Permitting and Inspections Department
Michael A. Russell, MS, Director

CBL: 013 C002001
Located at: 12 MONROE ST

Inspection Violations

Owner/Manager PENINSULA COMMUNITY LP		Inspector Jason Duval	Inspection Date 2/20/2018
Location 12 MONROE ST	CBL 013 C002001	Status Failed	Inspection Type Inspection

BASEMENT PLAN

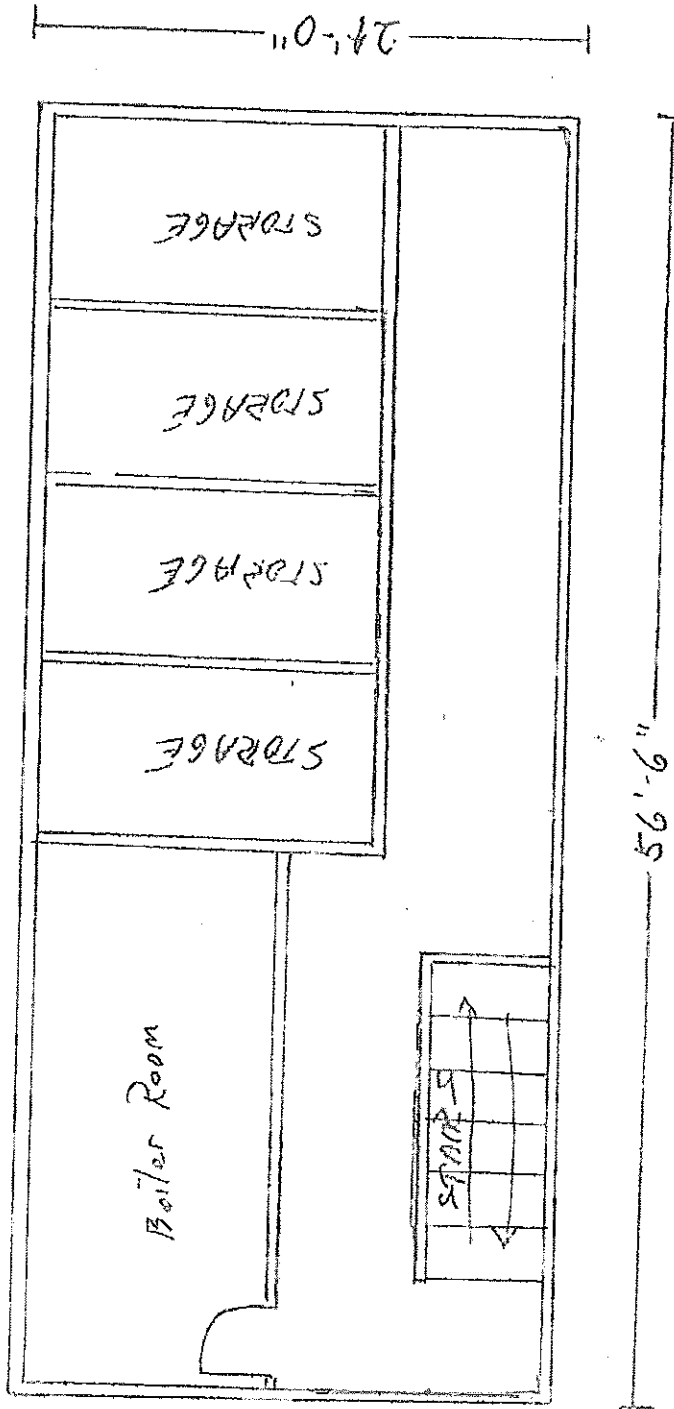
Notes: Sprinkler required for boiler protection.

Notes: Co alarm required for unit C and basement area.

Comments: Field Inspection 2/20- Unit C needs CO alarm on first floor. Egress blocked form one of the unit doors. Sprinkler required for boiler protection. CO alarm required for basement.
